Cc: Anita Gardner
Subject: RE: A/85/18/RES

Cc: 'Anita Gardner'
Subject: A/85/18/RES

It is understood that the Highway Authority are satisfied with the application proposals, subject to the applicant providing swept path diagrams to demonstrate that refuse collection vehicles can safely turn within the site. I herewith can now provide you with an amended Block Plan that shows this level of detail. We trust that this is satisfactory, and you will be able to confirm this to the Arun District Planning Officer – Mrs Anita Gardner.

block+location plan

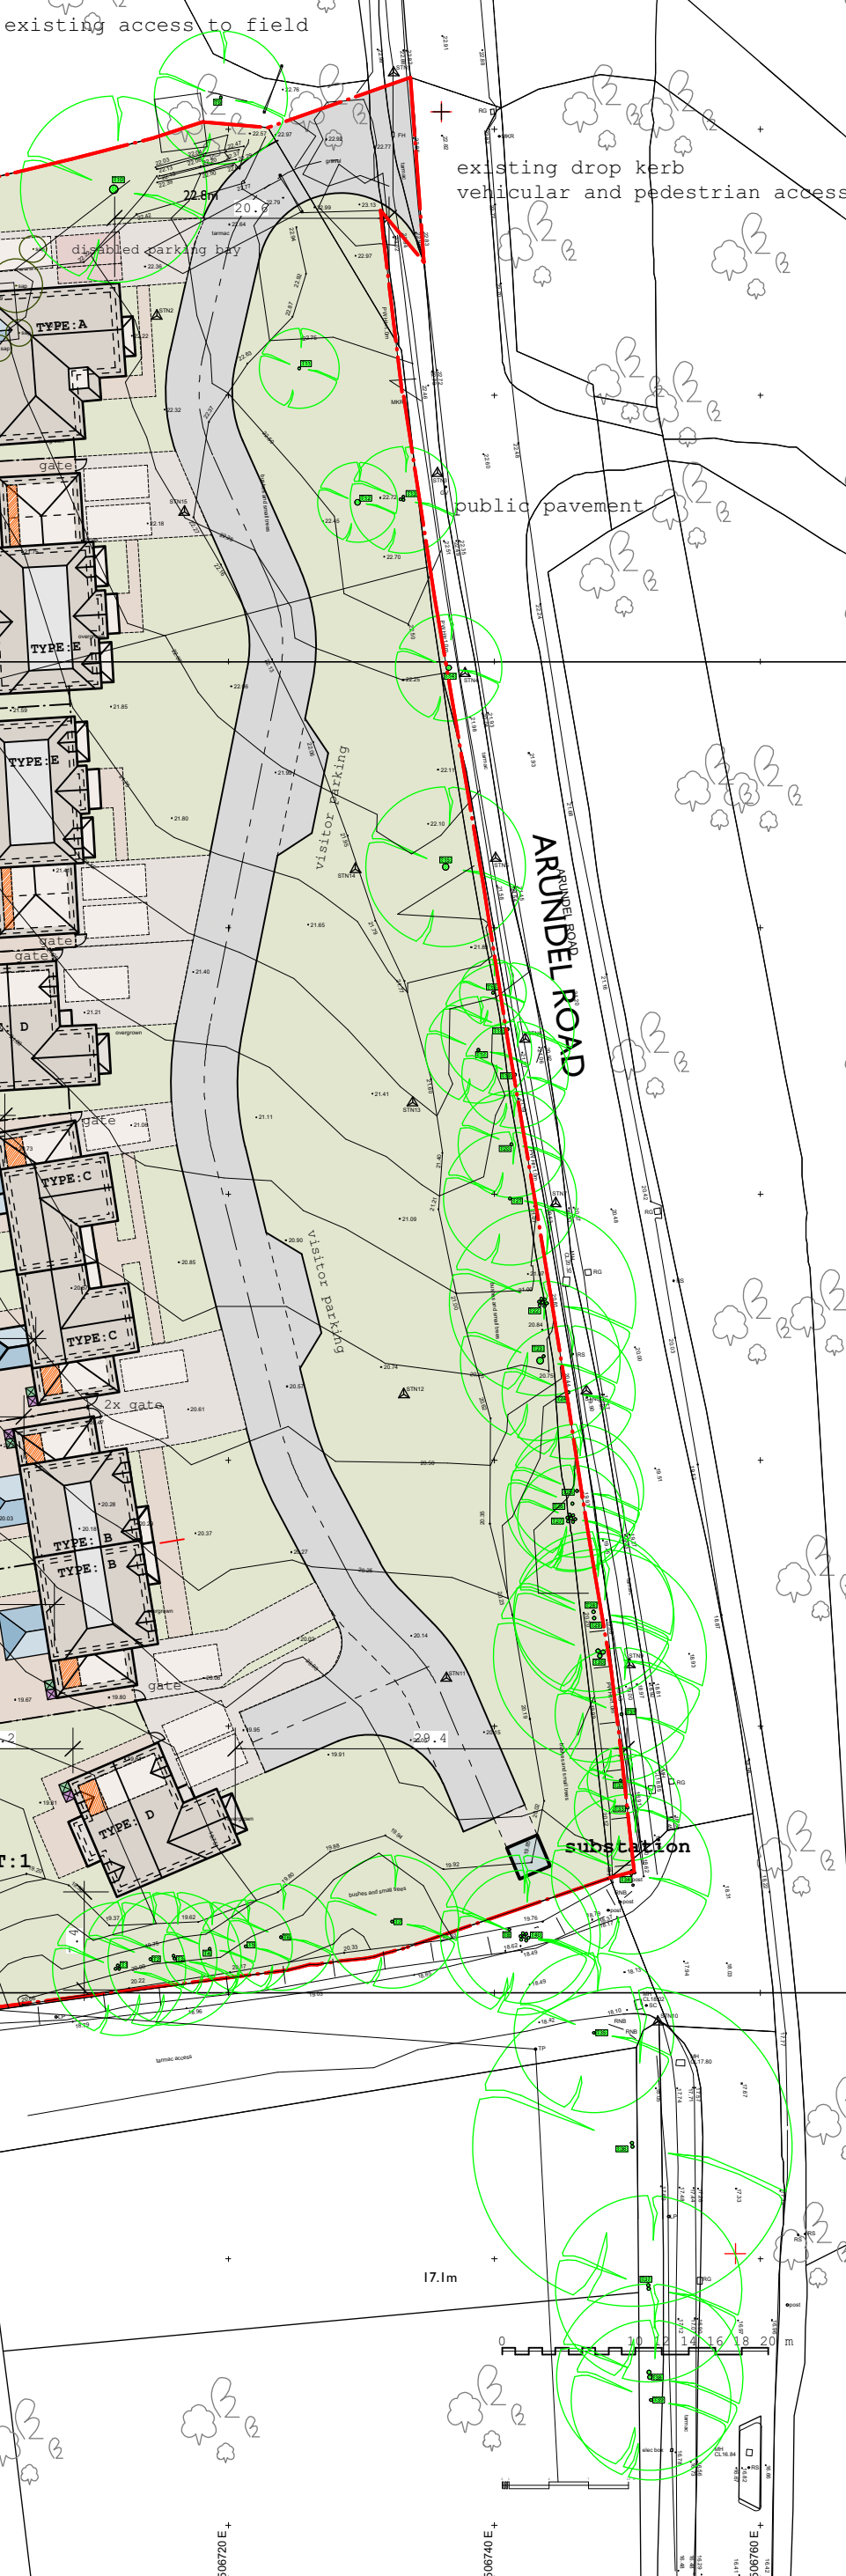
Thank you for your email and revised plan. I have reviewed the swept path diagram that you have provided and am satisfied that a waste collection vehicle can turn with the site. My only comment would be it might be worth ensuring that the turning head at the bottom of the estate road is marked out with a sign or hatching to discourage any visitor parking thus making the turning head restricted. On that basis I am satisfied with the proposals. I have CC'd Anita in for info.
